From: Harwood, Paul [REDACTED]
Sent: 19 April 2017 16:26
To: Bowie, David [REDACTED]
Cc: Vera Lamont [REDACTED]
Subject: FW: Land west of Brook Lane and South of A259 Angmering BN16 3JL.
Importance: High

Site: Land west of Brook Lane and South of A259 Angmering BN16 3JL.

Development: Outline application (with all matters reserved) for demolition of existing buildings on site and the erection of a mixed use development comprising 90No. residential units and a care home (Use Class C2 and C3) & ancillary facilities, including railway crossing, together with associated access, car parking & landscaping.

Planning Application No: A/44/17/OUT

Figure 6.2: Care Home Trip Distribution

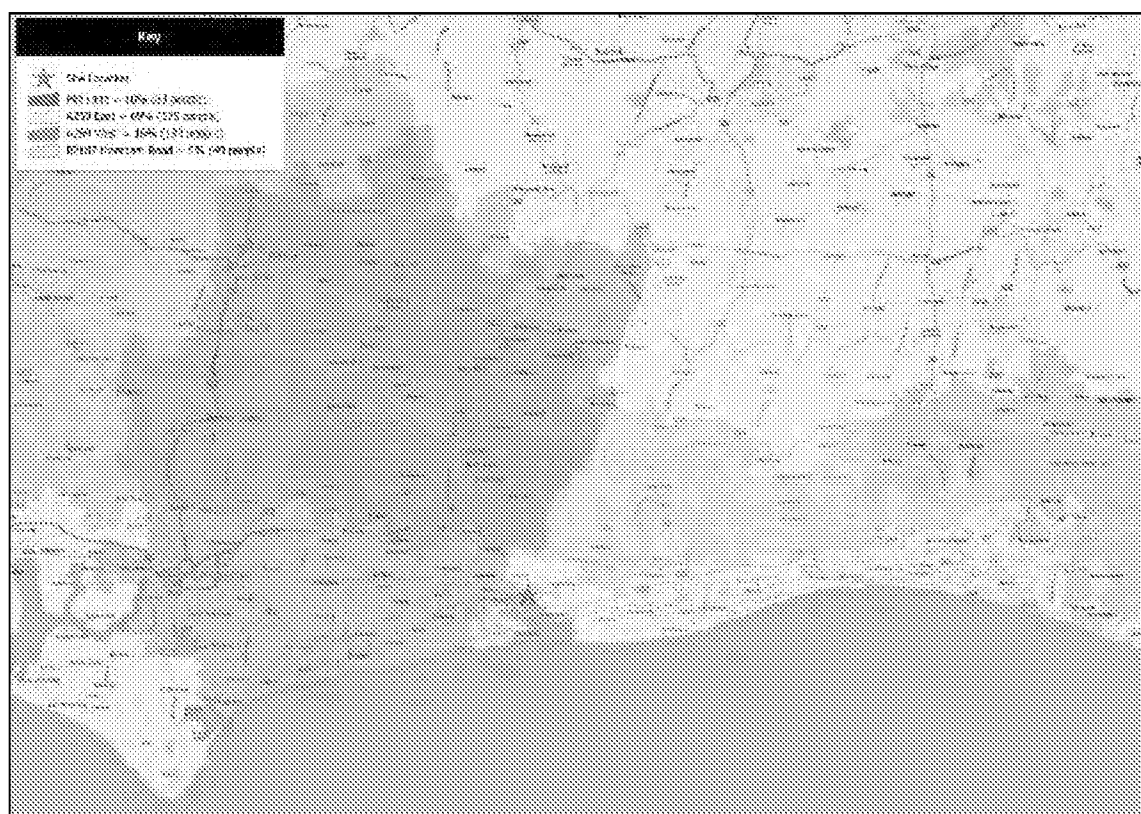
3. The trip distribution is not 100% clear - the site is directly accessed from the A259, yet the distribution also includes Horsham Road and Mill Lane (presumably these are accessed after the A259?) and thus it would be useful if a separate distribution and traffic flow diagrams were provided for development traffic only. Similarly, the distribution/traffic flows are not considered beyond the closest 2 roundabouts and thus it is not clear how many trips are expected to end up at the A27.
